**SSDA 7745 - SECTION 4.55(1A) MODIFICATION APPLICATION
NSW RUGBY LEAGUE CENTRE OF EXCELLENCE – SITE 18, DAWN FRASER AVENUE, SYDNEY OLYMPIC
PARK**

This application has been prepared by Ethos Urban on behalf of Adco Constructions, pursuant to section 4.55(1A) of the *Environmental Planning and Assessment Act 1979* (EP&A Act) to modify Development Consent SSD 7745 relating to the NSW Rugby League Centre of Excellence at Site 18, Dawn Fraser Avenue, Sydney Olympic Park (the site).

This modification application seeks approval to convert an existing void space at the Ground Level in order to provide a store room, provide solar panels on the rooftop and make a number of minor design changes. Accordingly, this letter identifies the consent, describes the proposed modifications and provides an assessment of the relevant matters contained in section 4.55(1A) of the EP&A Act. It is also accompanied by amended Architectural Plans, prepared by Populous (**Attachment A**).

PHASE: SD DRAWING NUMBER: AD.10.04.000 REVISION: C

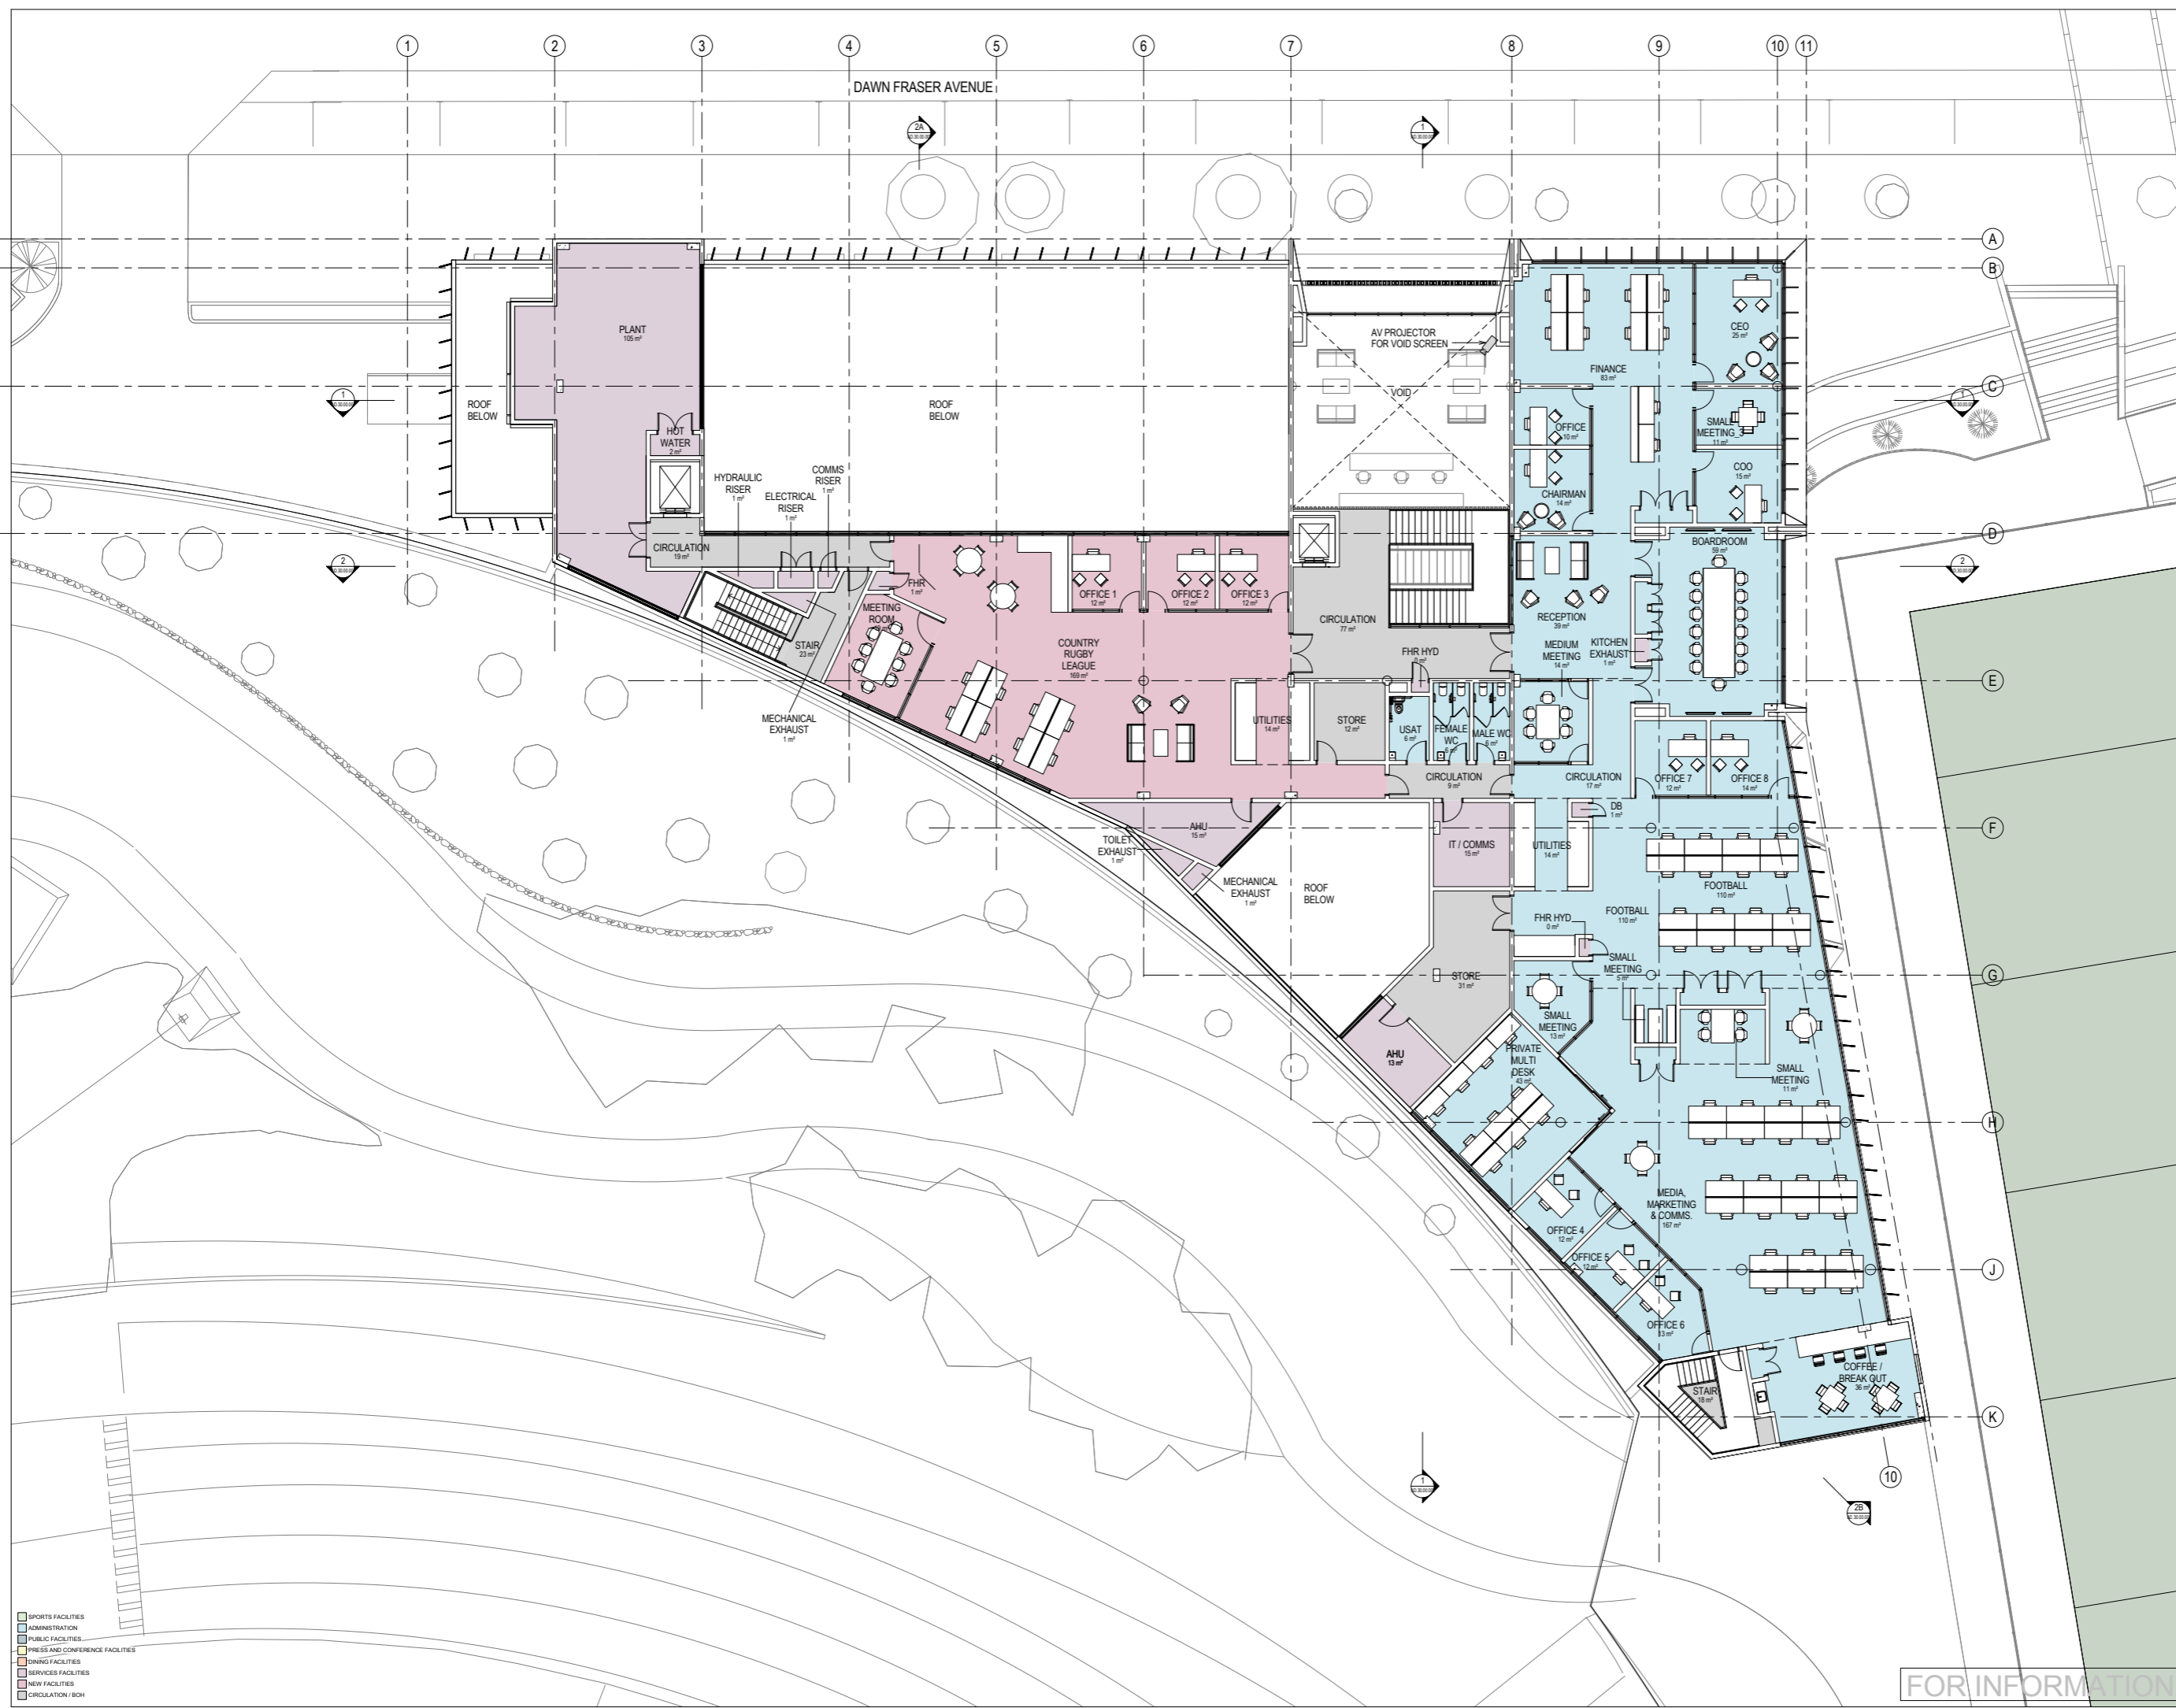
Level	Modification Description	Reason for Change
Ground	Conversion of the existing void space at Ground Level to a store room	The requirement to utilise the existing void space is the result of design development and the need for an additional storage area to be provided within the development.
	Provision of a double door between the store room and the café/street to allow access	The installation of the two sets of doors is required to provide both internal and external access to the store room.
	Provision of a door to the store room leading from Dawn Fraser Ave	
	Relocation of a gas regulator room and store room	Design Development
	Changes to amenities to provide a female toilet	Design Development
	Modification to the reduce the layout and extent of the Museum	Design Development
Roof	Change to a portion of roof materials	The western portion of the roof is proposed to change from tin to concrete to improve durability and future expansion opportunities. The concrete framing at the eastern portion of the roof is proposed to change from concrete to lightweight (tin) as a result of design development.

Amend a lift overrun	The lift feature is proposed to be reduced in height as the lift was able to be tucked beneath the roof sheeting.
	Inclusion of solar panels on the roof	The inclusion of solar roof panels on the Roof Level will improve the environmental performance of the building.

The proposed solar panels are 150mm in height. Accordingly, the proposed modification will increase the building height by 150mm from 14.44m to 15.94m. The increased height is minor, and the building remains well below the 26m permissible height for the site.

The solar panels are set back a minimum 300mm from the roof edge. As the panels sit flush against the roof, being 150mm in height, the setback will ensure that the panels are not visible from the public domain. Equally, the setback will ensure the panels do not create any overshadowing impacts.

Architectural (or Design) Drawings prepared by Populous:			
Drawing No.	Revision	Name of Plan	Date
AD.10.00.000	S 6	PUBLIC FACILITIES STREET LEVEL GA PLAN LEVEL 0	22/02/2017 27/06/2018
AD.10.04.000	N CC	Roof Level GA Plan Level 4	22/02/2017 24/07/2018
